From  
The Member-Secretary,  
Madras Metropolitan  
Development Authority,  
'Thalamuthu-Natarajan  
Building',  
No.8, Gandhi-Irwin Road,  
Madras-600 008.

Letter No. ~~IT/~~ DC/ 13826/89

Sub: MMDA - Planning Permission - Sub-division of  
house sites in T.S. No. 9, Block No. 54 of west  
mambalam. De & other charges - Reg.

PLAN SHOWING THE PROPOSED SUB-DIVISION  
 OF PLOTS AT DOOR NO. 17, BRINDAVAN STREET.

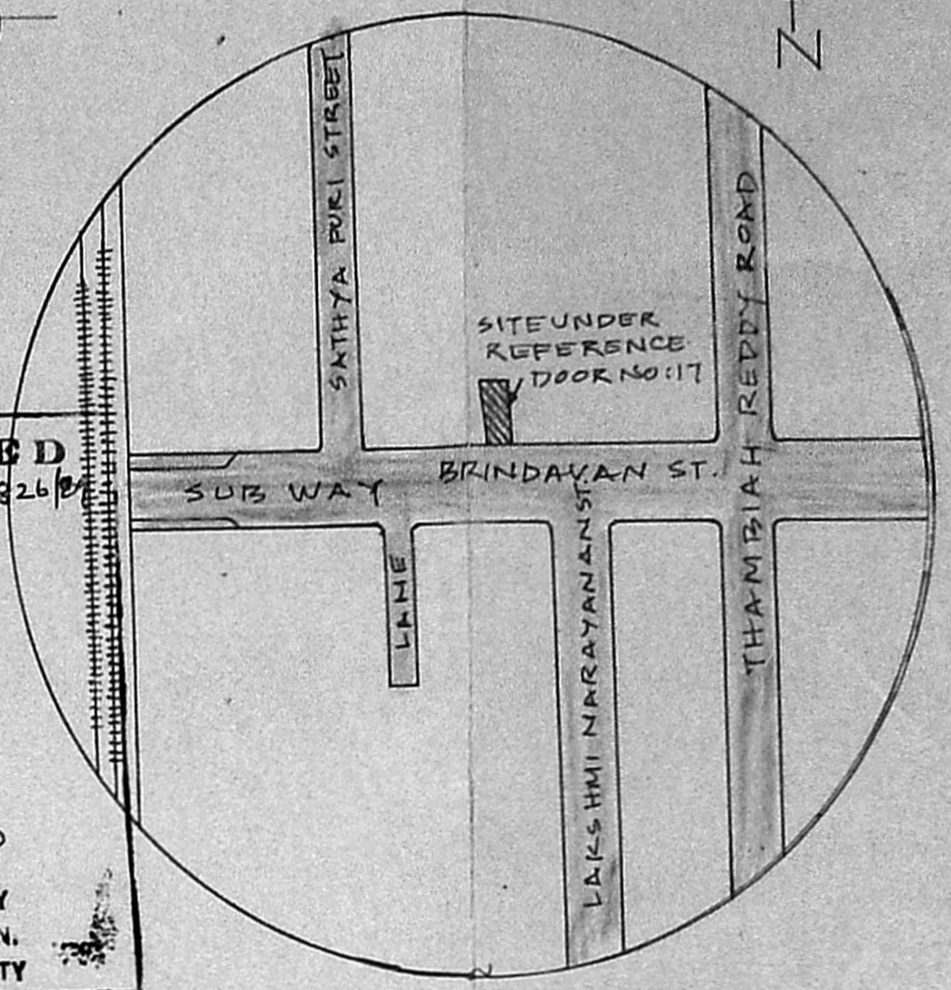
~~Village was examined and layout has been revised to satisfy  
the Development Control Rule requirements~~/Sub-division and  
found approvable. Subject to the removal of ~~concretes~~ in the  
front.
